**Dendrobium Mine Extension Project (SSD-8194)  
EIS Exhibition**

Jim Bentley  
CEO (Deputy Secretary) Water  
**Department of Planning, Industry and Environment - Water**  
23 October 2019

### **Detailed advice to DPIE Planning & Assessment regarding the Dendrobium Mine Extension Project (SSD-8194)**

Figure 6-9 Project Mining Constraints for Named Watercourses, Key Stream Features and Water Supply Infrastructure

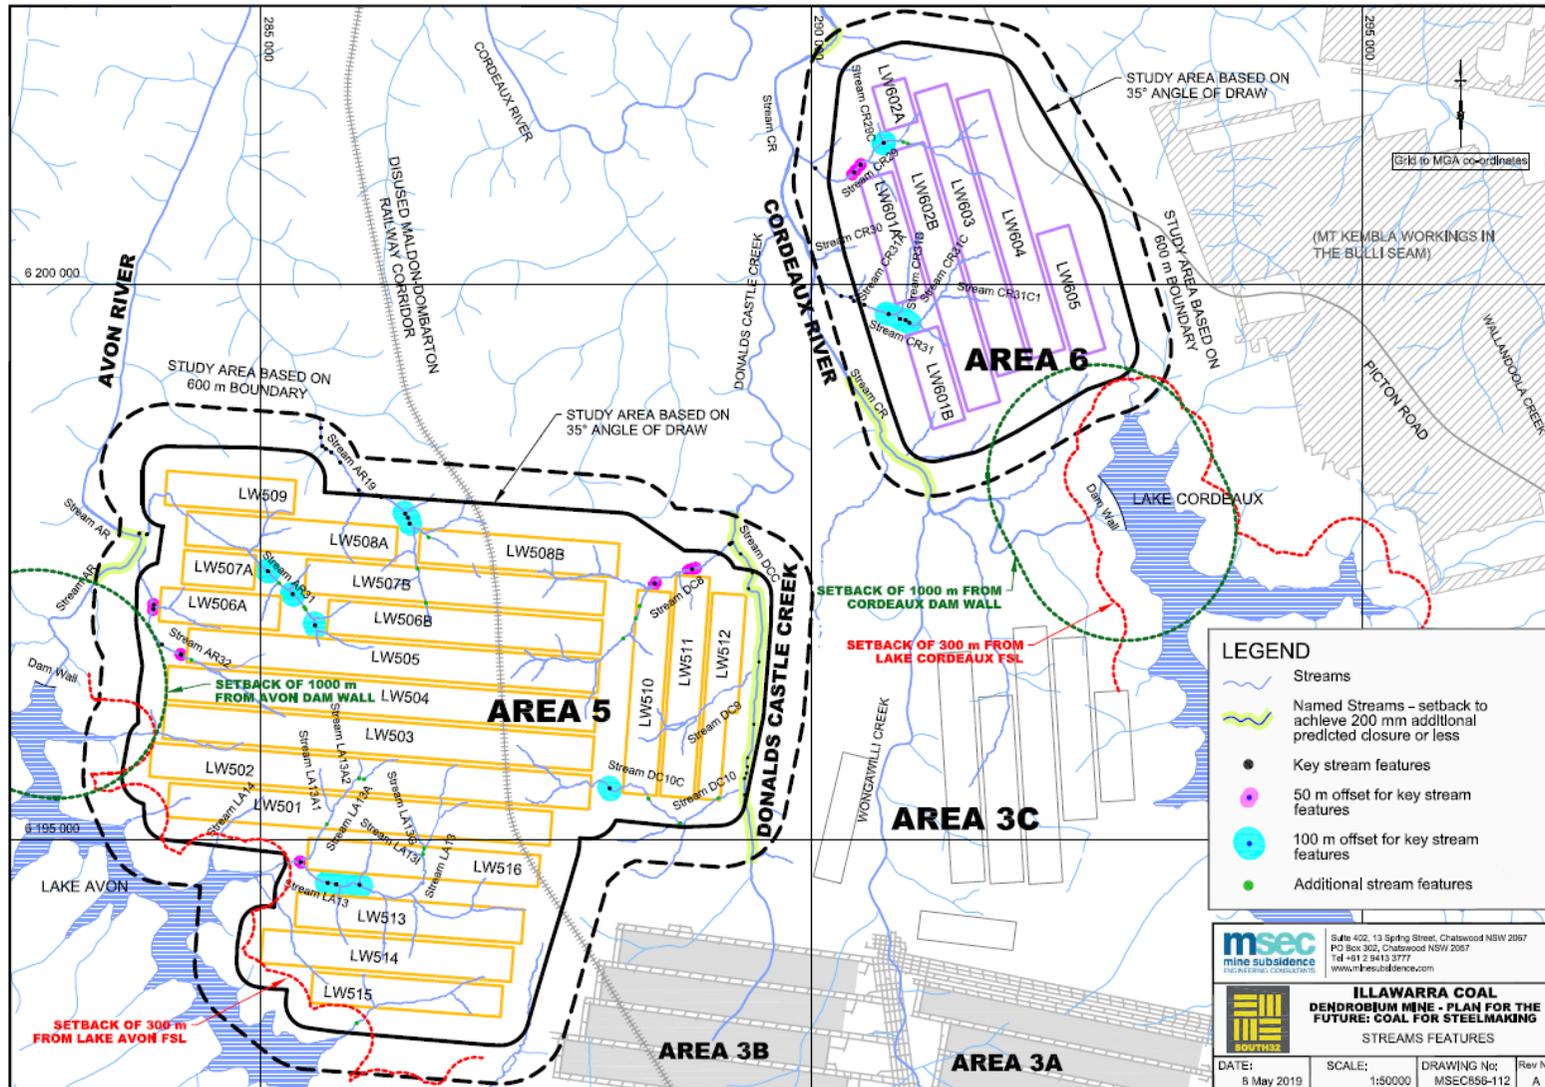
Protective setbacks and other measures are proposed for the Avon River, Cordeaux River and Donalds Castle Creek. Other watercourses, including five 3<sup>rd</sup> order watercourses in Area 5 and three 3<sup>rd</sup> order watercourses in Area 6 are not protected to the same level. The effectiveness of the proposed protection is uncertain. These other watercourses are predicted to have valley closure impacts of between 275-1150 mm and upsidence impacts of between 400-875 mm.

We are concerned about the criteria used to assign significance to watercourses overlying or adjacent to the predicted subsidence zone for Dendrobium Areas 5 and 6. The EIS does not provide geomorphic or hydrologic justification for the use of the 'Key' stream features of pools with holding capacities greater than 100m<sup>3</sup> capacity or waterfalls greater than 5 m height. These criteria may reduce any obligation to reduce longwall lengths to avoid direct subsidence of overlying swamps and connected watercourses.

- Revise the geomorphologic criteria used to nominate significance in relation to watercourses and upland wetlands and identify key threats to geomorphic features that form controls on pool form, wetland outlets and elevated chutes, cascades or waterfalls.
